DOC22/221850

28 March 2022

**Moss Vale Plastics Recycling Facility (SSD 9409987)
EPA advice on the Environmental Impact Statement (EIS)**

Figure 5.3 Contribution of the modelled noise sources at R160 - 50a Bulwer Rd, Moss Vale

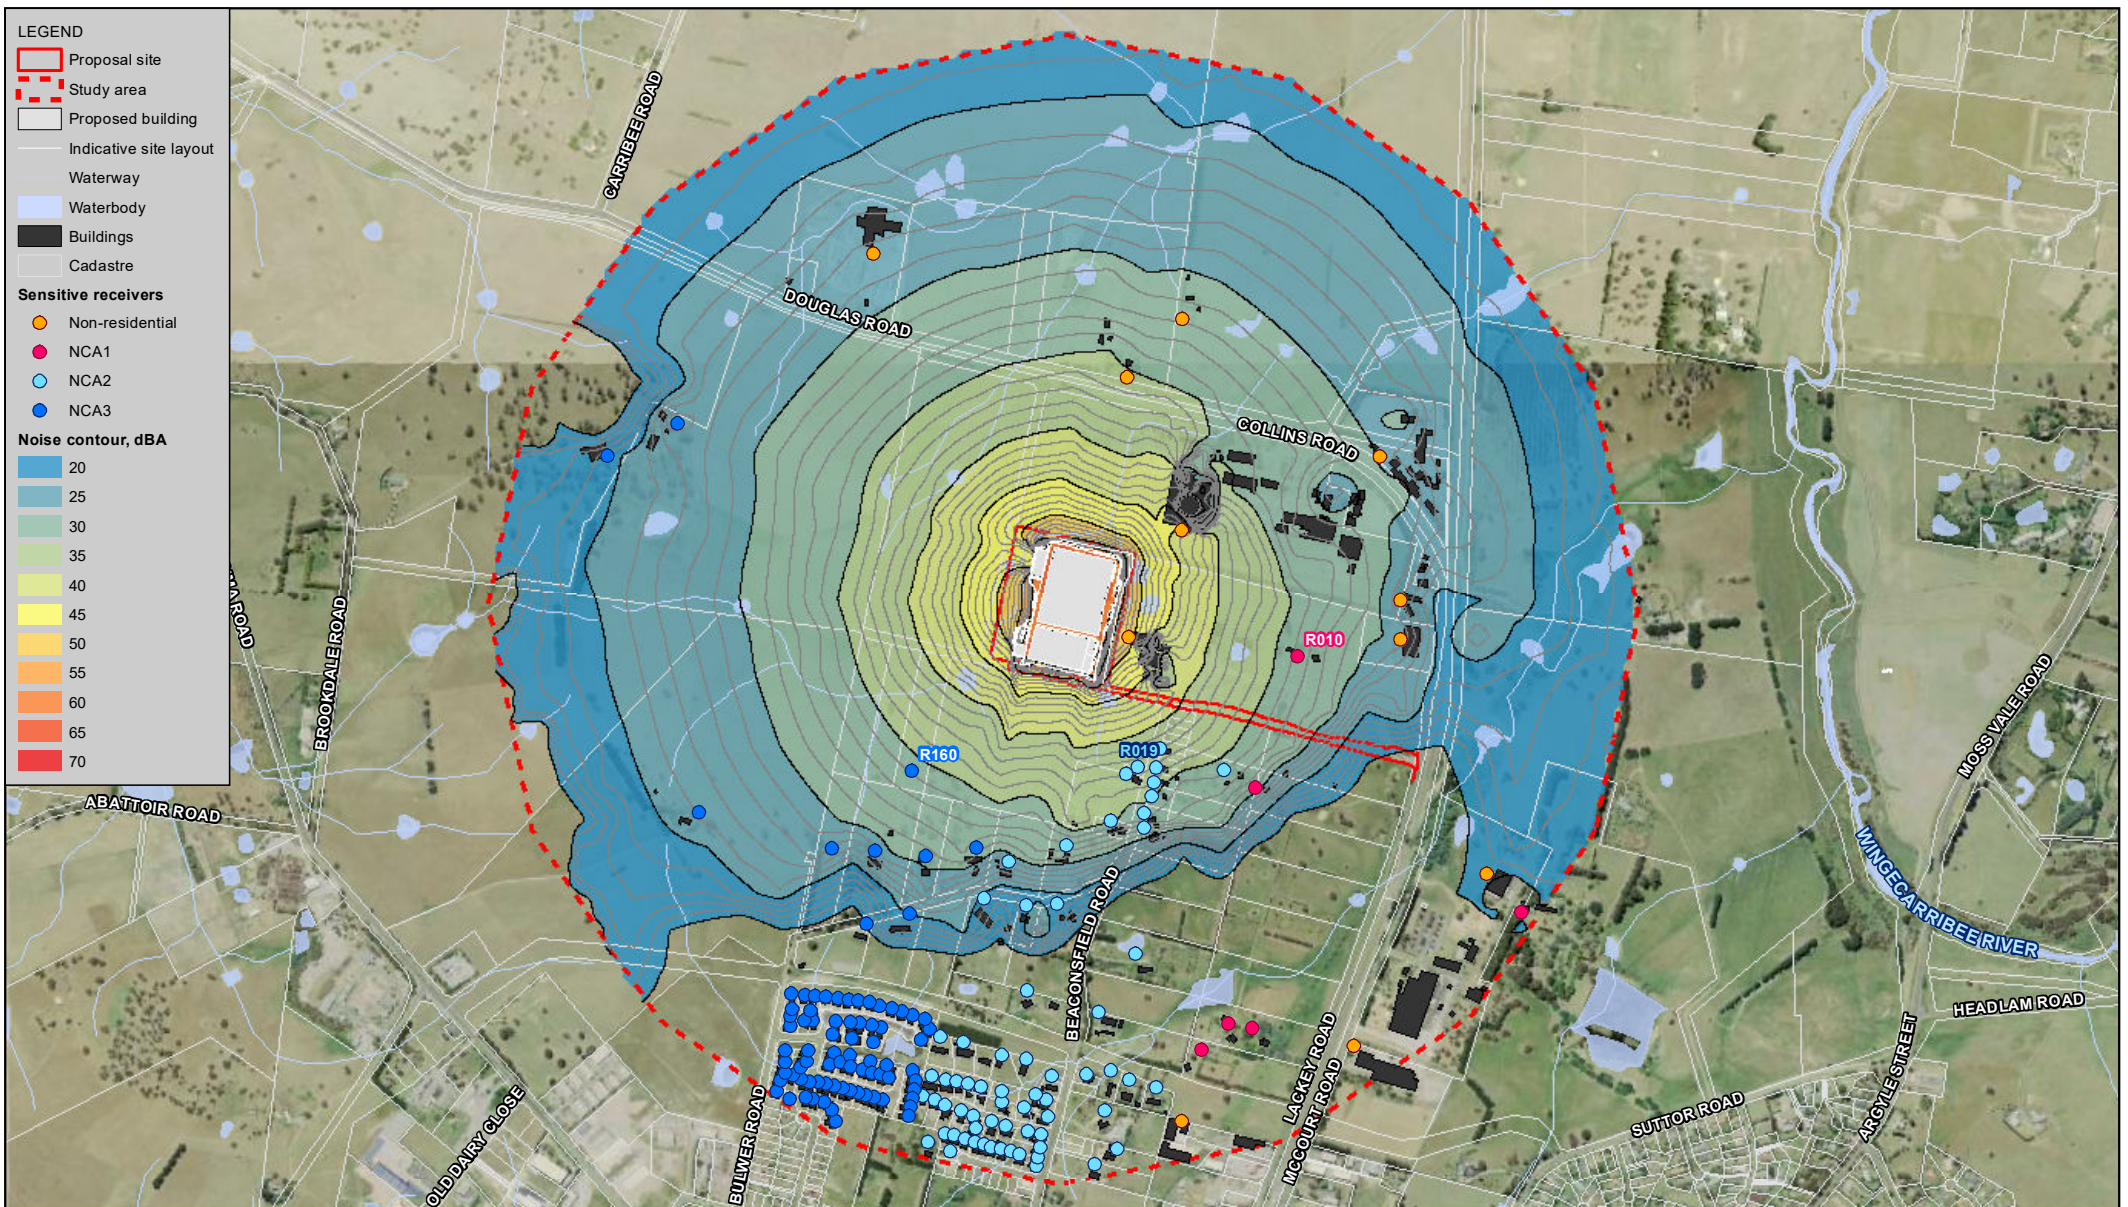
The predicted noise levels at receivers R019 (NCA2) and R160 (NCA3) under noise-enhancing meteorological conditions at night are equal to the project noise trigger levels. NVIA Chapter 5 and Appendix F state that the predictions are based on a number of assumptions, which in turn are based on similar plants, and reliance on meeting specific internal noise levels. Building 1 appears to require mobile plant operating within to feed the processing machine 24 hours a day. This, together with the industrial machinery, makes it unclear if the proposed 85 dBA internal noise limit is achievable without further information. Therefore, the EPA considers there is a risk of impacts above those predicted in the NVIA.

The NVIA states that the highest contributors to these noise levels are: the Building 2 stacks, breakout from various elements of Building 1, and wastewater treatment plant fans. NVIA Chapter 6.2 provides recommendations for mitigation, including that the façade construction meets a noise reduction performance specified in NVIA Appendix F.

- DPE carefully consider the risks associated with the current status of the design and, if approved, include conditions that account for this.
